# CITY OF ALBUQUERQUE

August 21, 2015

**Re: Tract A, B-1 and C-1 Sandia Addition  
Grading and Drainage Plan  
Engineer's Stamp Date 8-18-2015 (F17D095B)**

TRACTS A, B-1, AND C-1 SANDIA ADDITION	DRAWN BY SMT
	EXHIBIT 1 DRAINAGE PLAN	DATE 07-28-15
	FLOYD DEVELOPMENT SERVICES, LLC DEVELOPMENT, ENGINEERING, & WATERSHED CONSULTING 918 PINEHURST RD SE, SUITE 102 RIO RANCHO, NM 87124 HUGH@DEVELOPNM.COM 505-366-4187	SHEET # 1 of 2
		JOB # 013-15-300

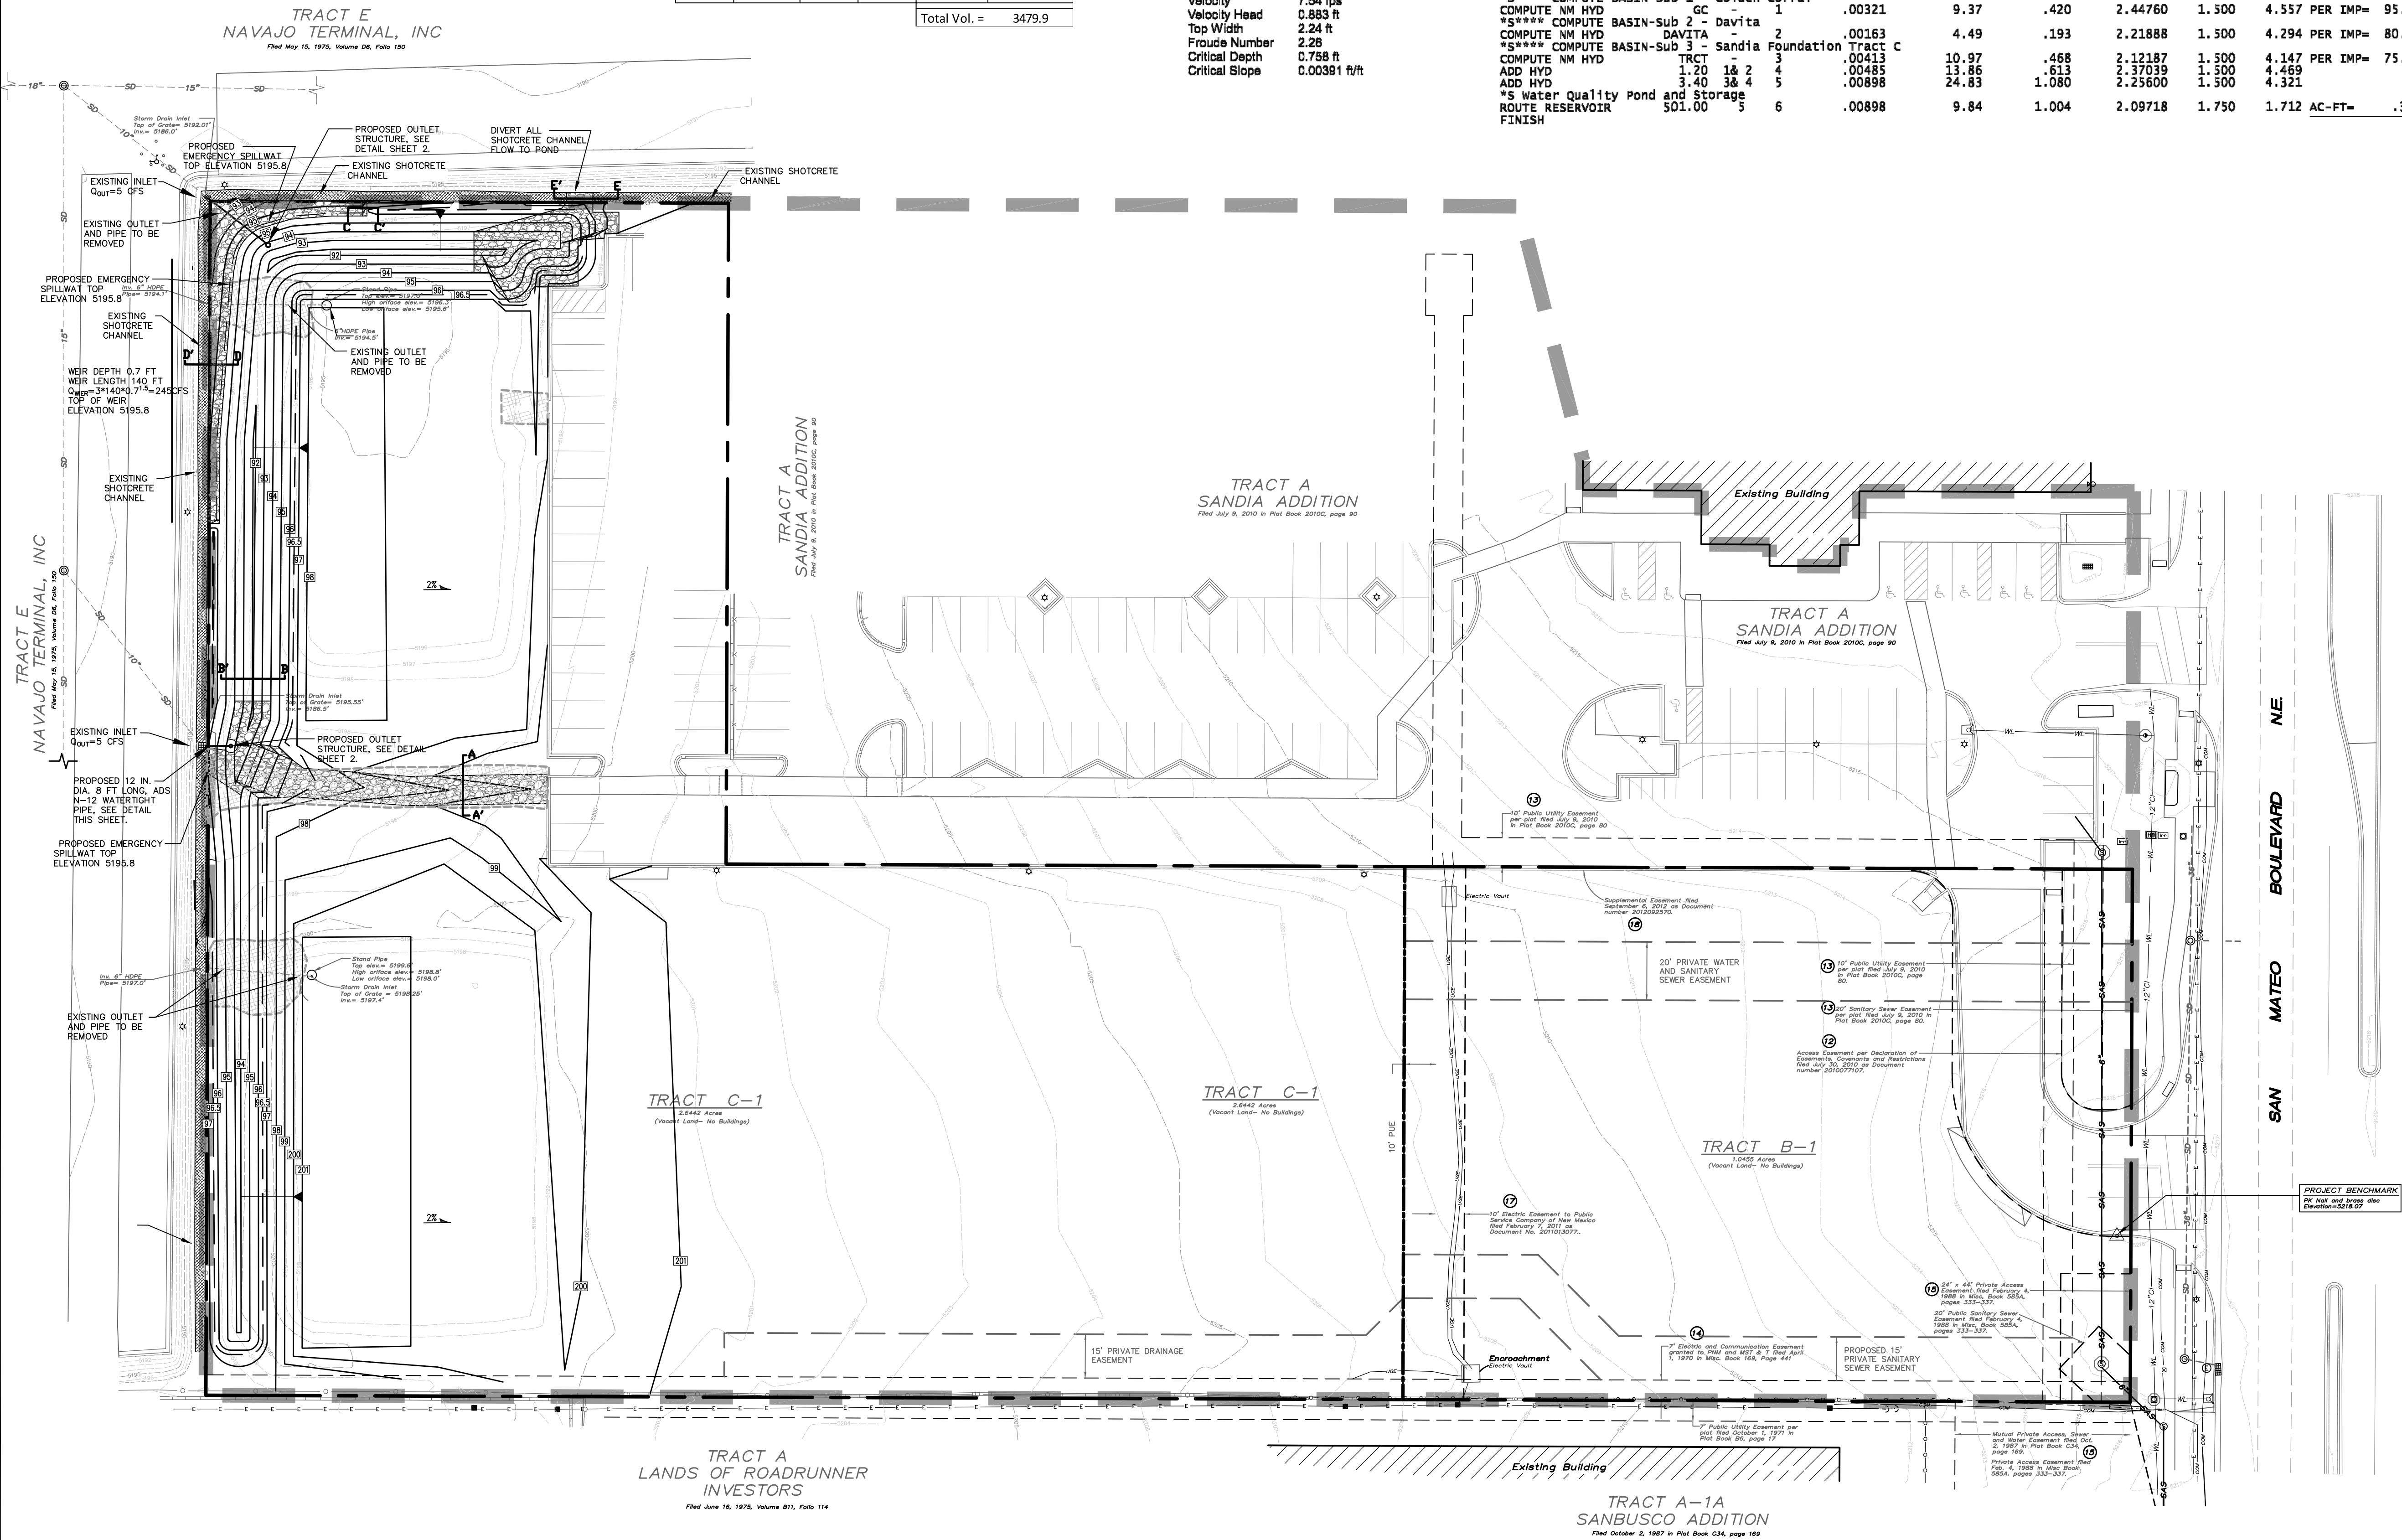
- Make sure that the top of beehive is constructed at 5194 and top of pipe is at 5193.
- An Erosion and Sediment Control Plan (ESC) submittal is also required. Please submit an ESC plan including a submittal sheet to Curtis Cherne for review and approval.
